**KIRKLEES METROPOLITAN COUNCIL  
INVESTMENT & REGENERATION SERVICE**

**Reference No:** 2017/61/94229/E

**Site Address:** Land Off, Healey Lane, Batley, WF17 7BN

**Description:** Reserved matters application pursuant to outline permission 2014/92328 for residential development (15 dwellings)

Plans and Elevations scale 1:100 07/04/2017 drwg no. 2605-17-01

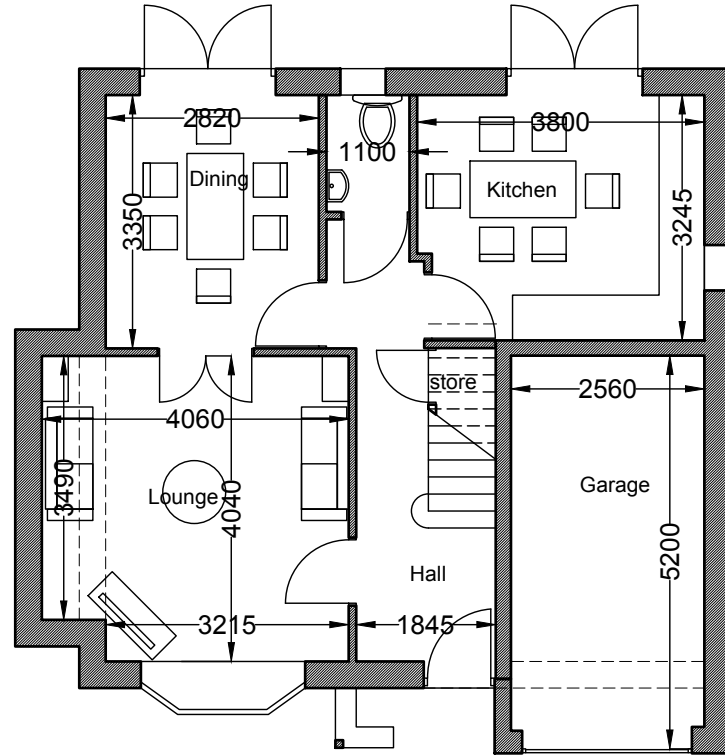
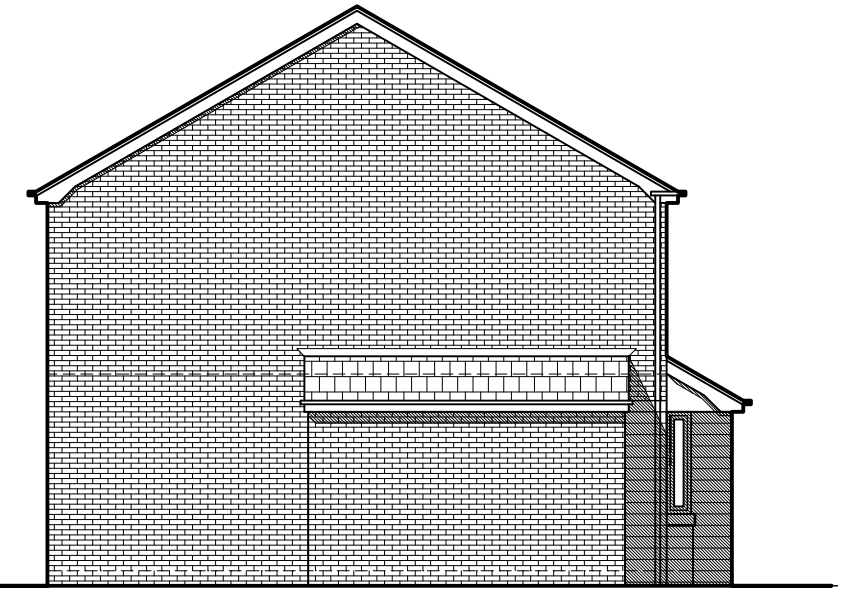
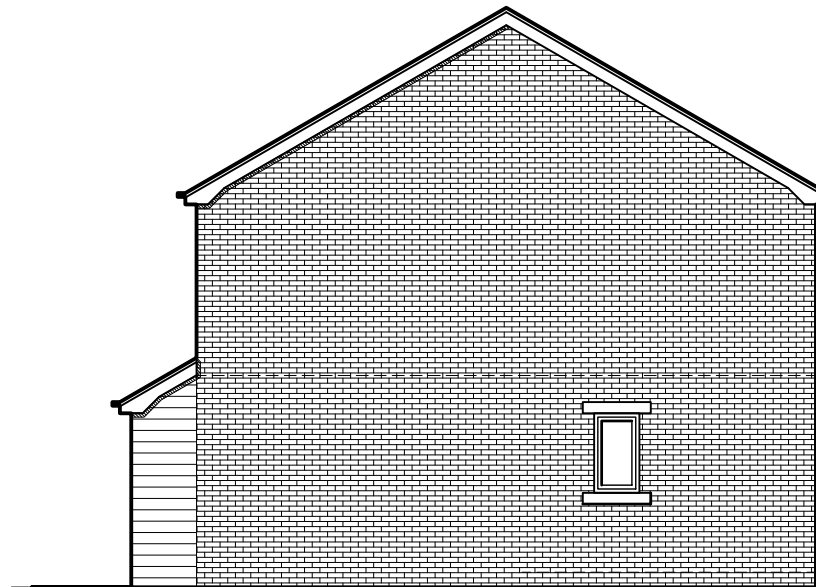
- *I am pleased to see that units 1-3 and 13-15 would properly address and help to activate Healey Lane. Could units 6-12 similarly address and activate West Park Road? The current proposal suggests those units would turn their back on this important road. Could they be redesigned so that they have their main front doors facing the road (and paths and gates providing access to the pavement, which may be possible in the light of the Arboricultural Officer's comments), but still had their garages and back doors facing the cul-de-sac?*

- *Could units 6-12 be staggered slightly, instead of built in a regimented row with the same front building line? I think this would help reflect existing patterns of development in the area, and would augment the narrow gaps between these properties.*

Of the above unresolved matters, the orientation and design of units 6 to 12, and the need to properly address West Park Road, is the most crucial. In the current proposals, those units would turn their back on the most important highway abutting the site, resulting in a development that would fail to address and engage with the public realm. The regimented row of seven detached dwellings – all with the same rear building line and with similar rear elevational treatments – would have a poor, unrelieved appearance that would further give the impression of a development that turns its back on the public realm. These aspects of the proposed development are considered unacceptable.

In their consultation response, the Coal Authority stated that, within the application site and surrounding area, there are coal mining features and hazards which need to be considered in relation to the determination of this application for Reserved Matters approval. The Coal Authority's records indicate that there is a mine entry close to the southeastern corner of the site with a zone of influence which extends into the site. This poses a significant risk to ground stability and public safety, with plots 6 and 7 being of particular concern.

*"For your information the ground investigation has shown the possibility of a disused shaft in the area of plot 6 and 7 so we need to do some ground scraping on site before I can revise the layout to ensure I'm not proposing a building over it (if it turns up on site. It could be under the road)".*
